Northedge Design
21, Emblem Court
Queensbury
Bradford
BD13 2SNKirklees Direct
Tel: 01484 414746
Email: joanna.rednall@kirklees.gov.ukDate: 08-Sep-2025
Our Ref: 2025/92174

TOWN AND COUNTRY PLANNING ACT 1990
TOWN AND COUNTRY PLANNING (GENERAL PERMITTED DEVELOPMENT) (ENGLAND)
ORDER 2015 – SCHEDULE 2, PART 1, CLASS A.1 (g)
AT: 190, Lindley Moor Road, Lindley Moor, Huddersfield, HD3 3UE
Prior notification for single storey rear extension

The Authority has considered your application and it has been determined that the proposal is not acceptable and prior approval is hereby **Refused** for the following reason(s);

Proposed Elevations

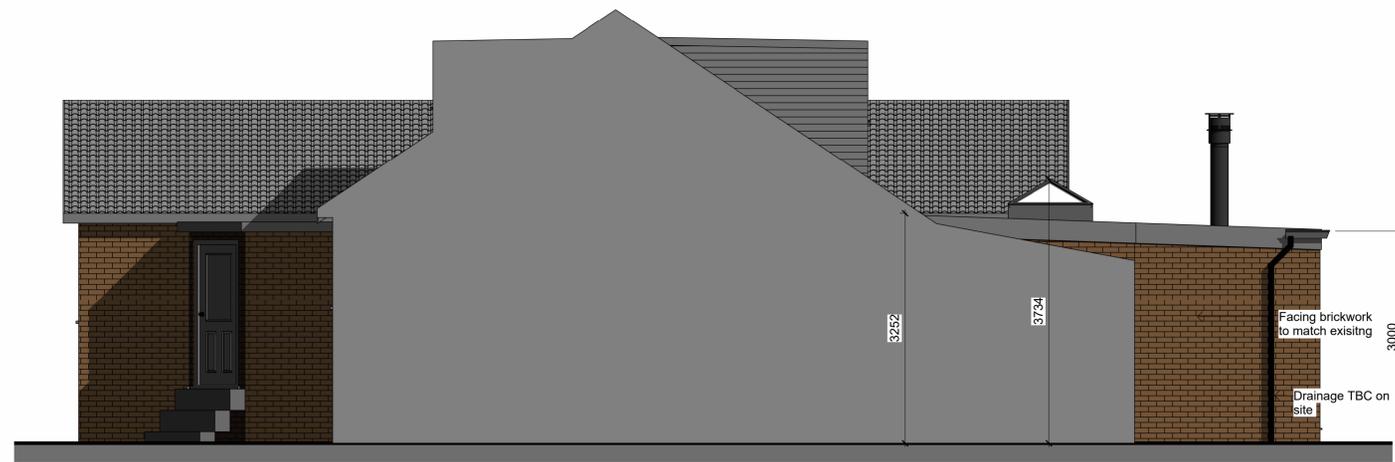
The proposal is for erection of single storey rear extension. The extension projects 6m beyond the rear wall of the original dwellinghouse. The maximum height of the extension is 4m, the height of the eaves of the extension is 3m

The proposed rear enlargement cannot benefit from a general planning permission under Article 3(1) and Schedule 2, Class A, Part 1 of the Town and Country Planning (General Permitted Development)(England) Order 20156 (as amended) as the proposed enlargement would extend beyond a wall forming a side elevation of the original dwellinghouse and has more than half the width of the original dwellinghouse contrary to sub-paragraph A.1(j) of Class A.
